Application No: LU/312/20/HH
Site Address: 18A River Road Littlehampton BN17 5BN
Description of works: Part conversion of garage to create an self contained annex

Thank you for your internet representation made on 18th January 2021 which has been recorded as an objection with the comments as follows:

proposed ground floor plan:
No change to elevations:

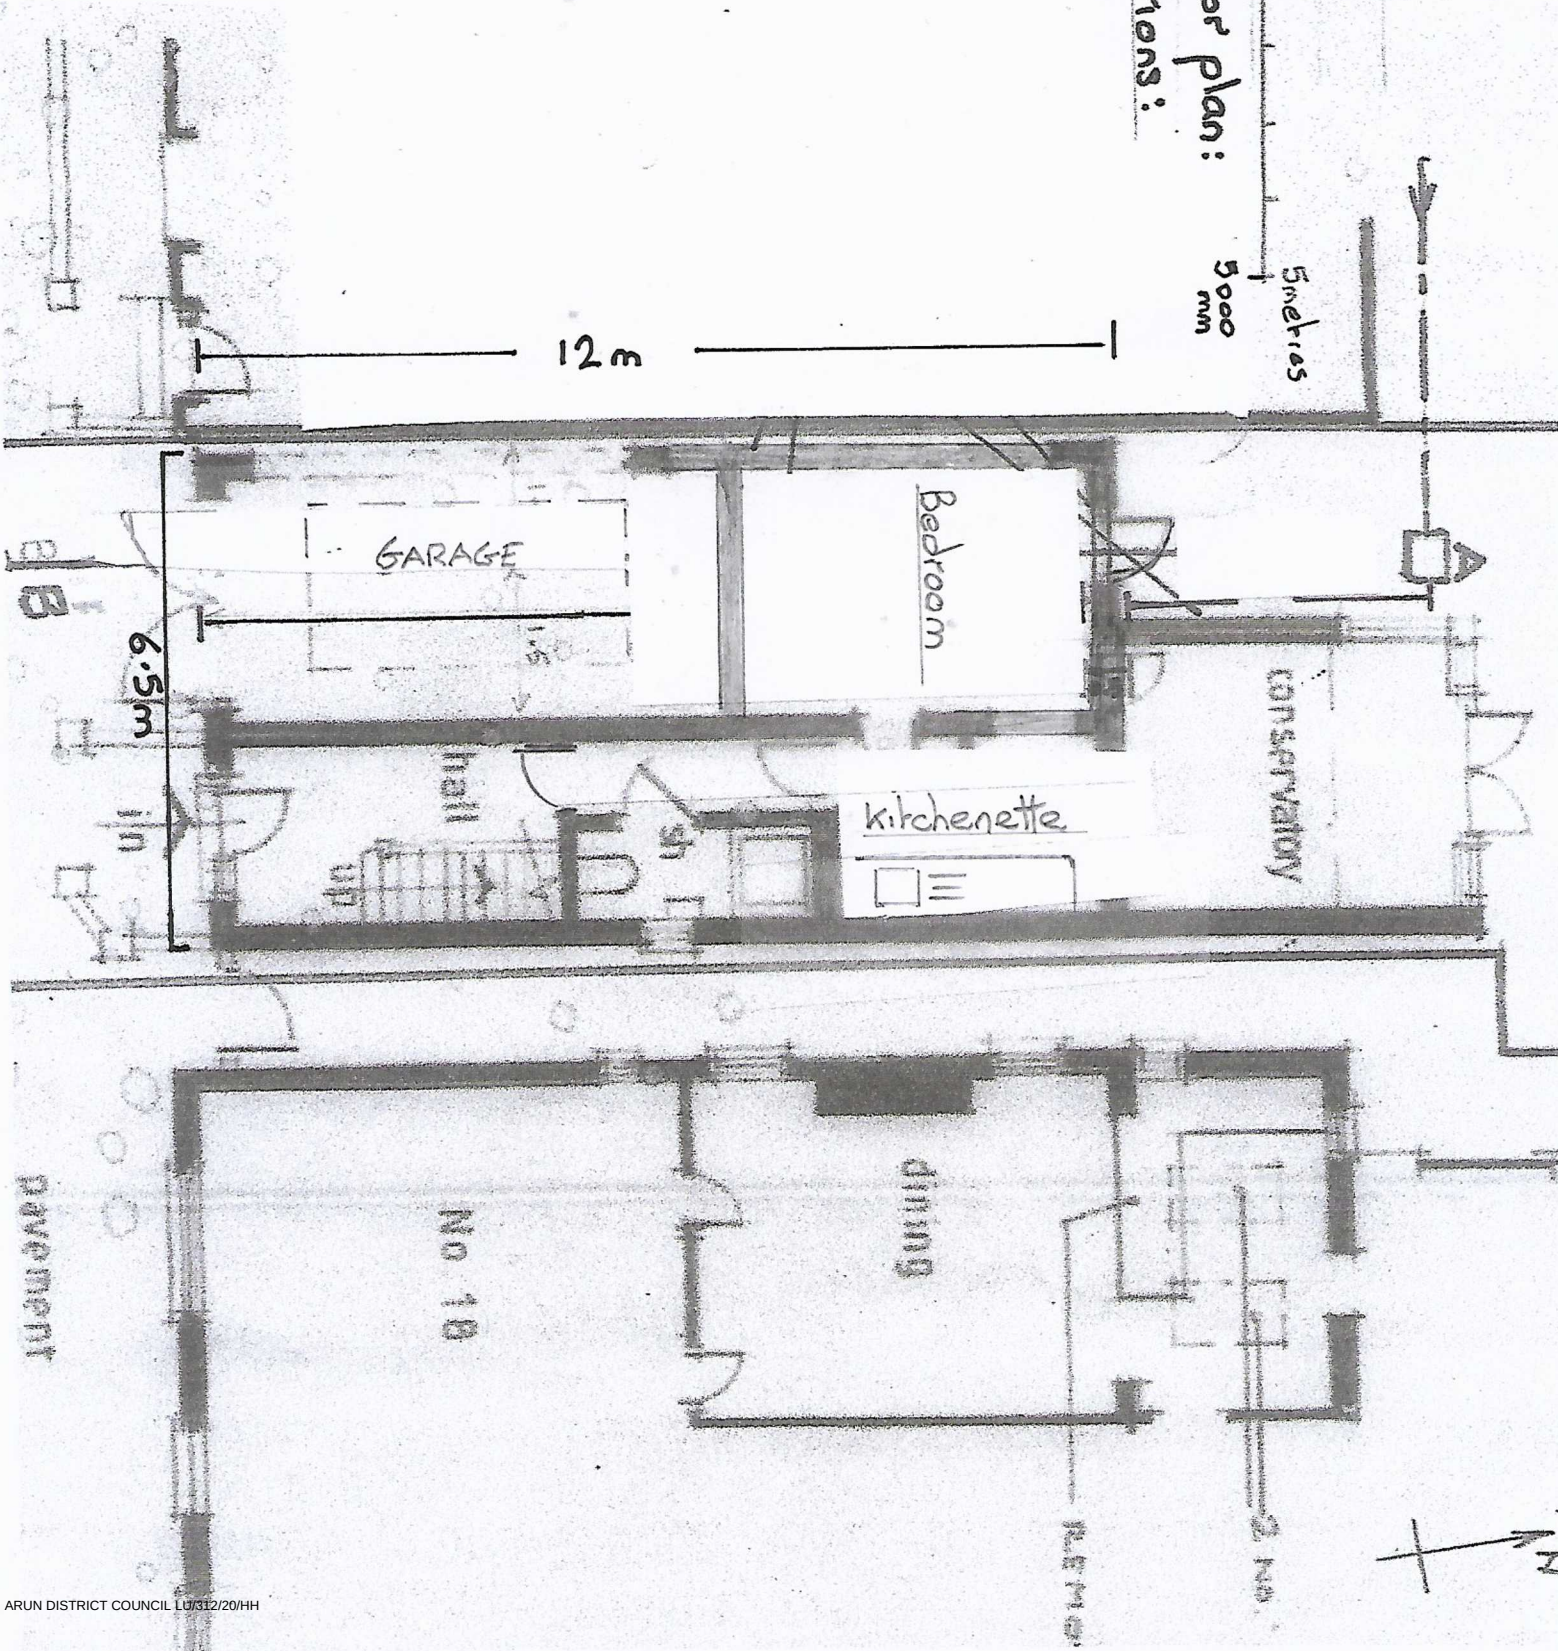
1. There is to be no living accommodation on the ground floor and the finished habitable floors were to be no lower than 6.05m.
2. The car parking area cannot be used for any other purpose than parking vehicles.

This building now appears to be two flats plus an annexe. Previous applications to build blocks of flats on this site were refused.
